Your ref:	Giolato	Please reply to:	Fraser Fikrie
Our ref:	21/04302/ADV	Tel No:	0753424 7967
		Fee Queries:	0207 641 6500;
		Email:	planningreception@westminster.gov.uk;
mrs sally Williams YELLOW WREN DESIGN LTD The loft studio 8 colwell road Haywards Heath RH164ES United Kingdom		Incomplete Applications Development Planning City of Westminster PO Box 732 Redhill, RH1 9FL	
		7 July 2021

Address: 15 Strutton Ground, London, SW1P 2HY

Proposal: Display of externally illuminated fascia and hanging signs measuring 1.45m x 0.27m and 0.40m x 0.40m.

Thank you for your application received on 26 June 2021. I am writing to inform you that your application is incomplete for the following reason(s):

PROJECT No.	DWG No.
REVISION 2021 - 025	40-01 A

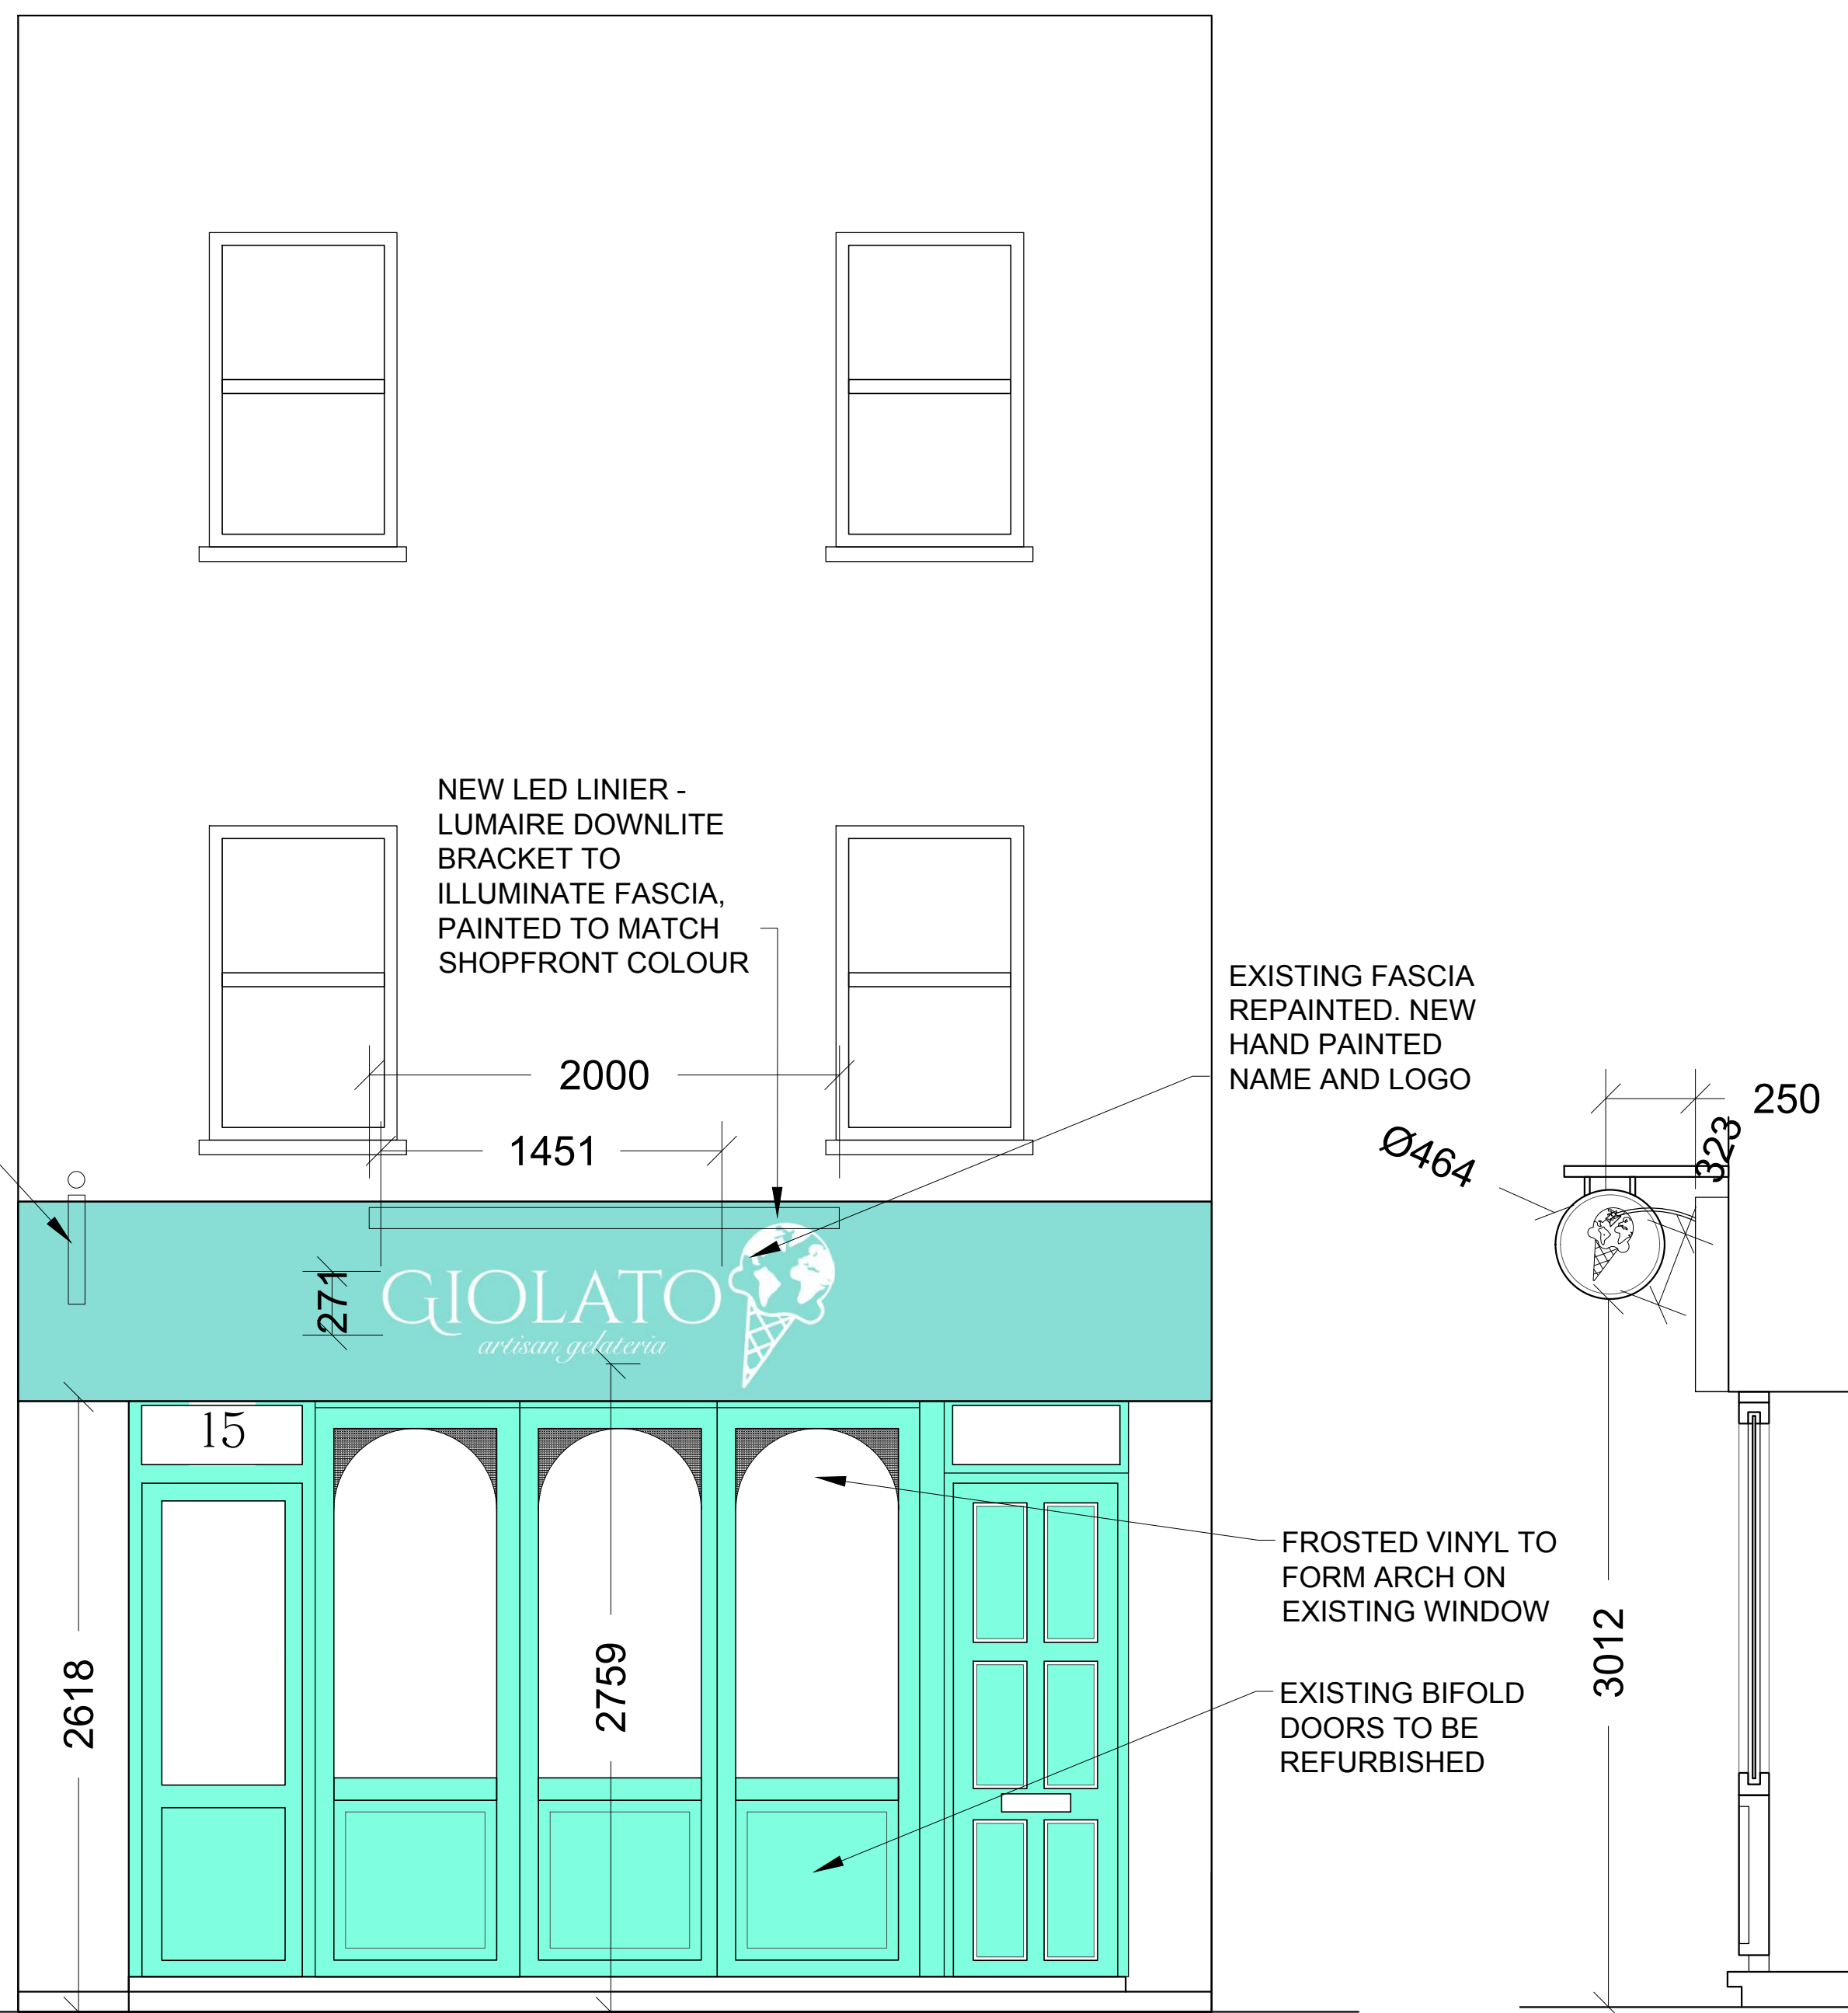
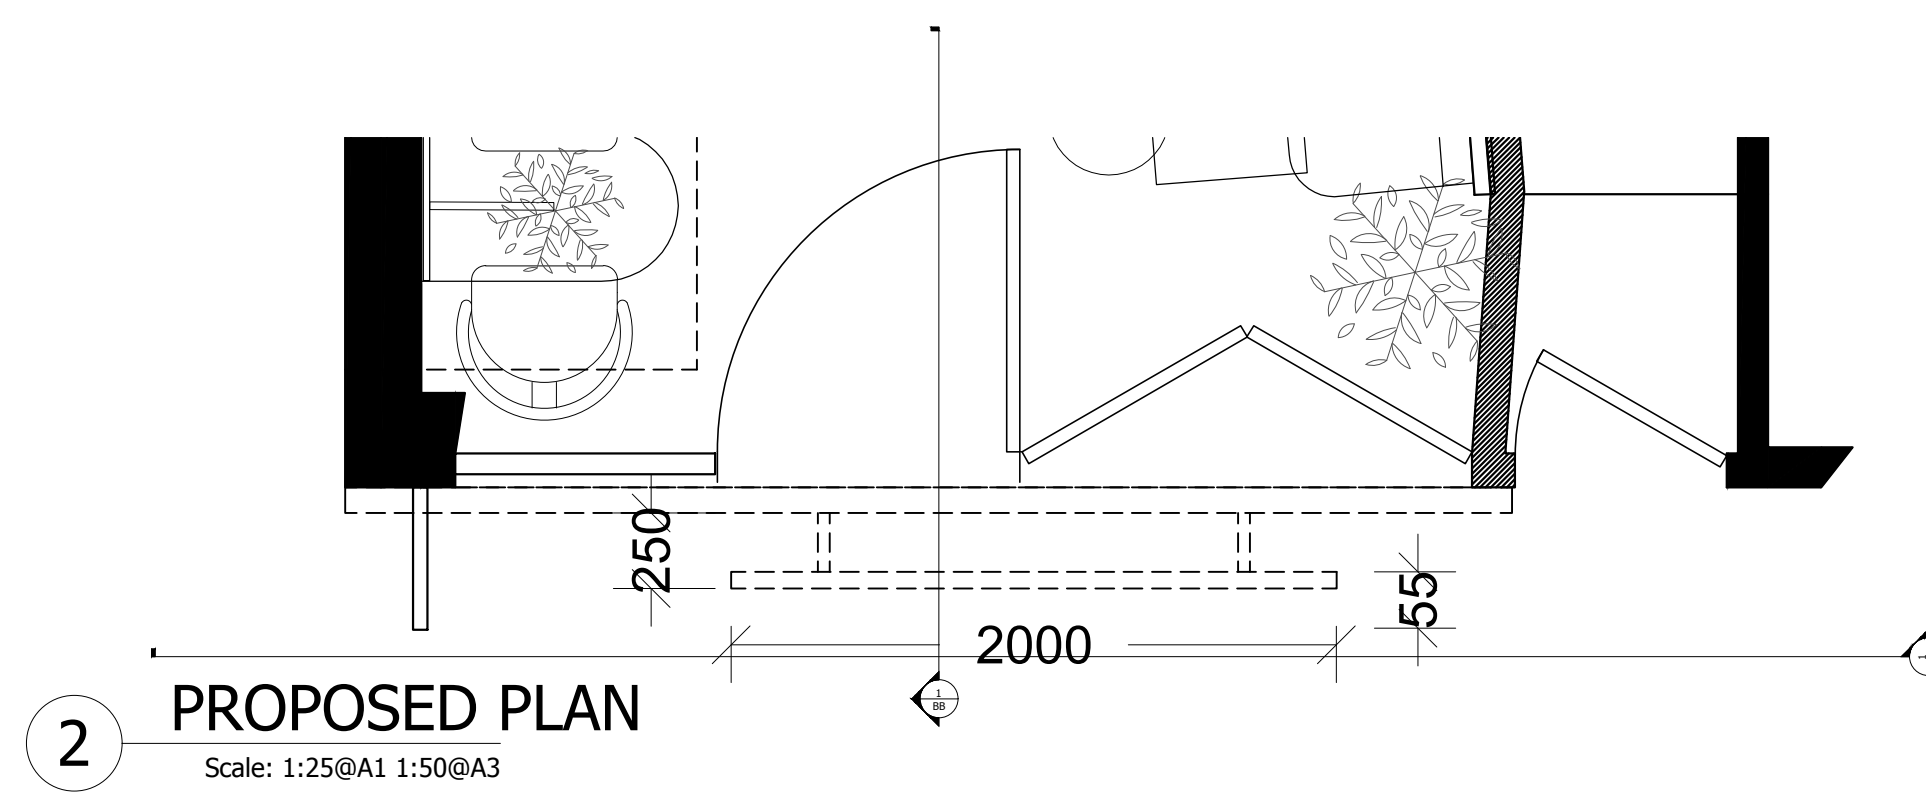
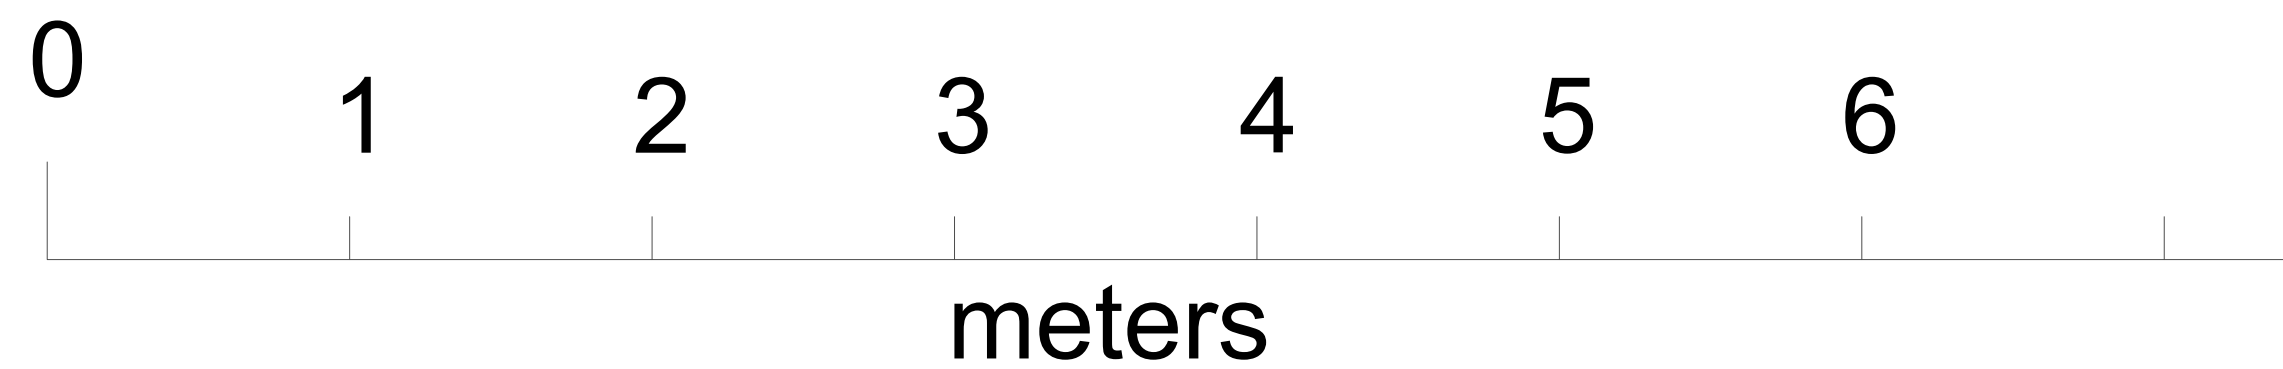
- Detailed drawings and specification of the external lighting
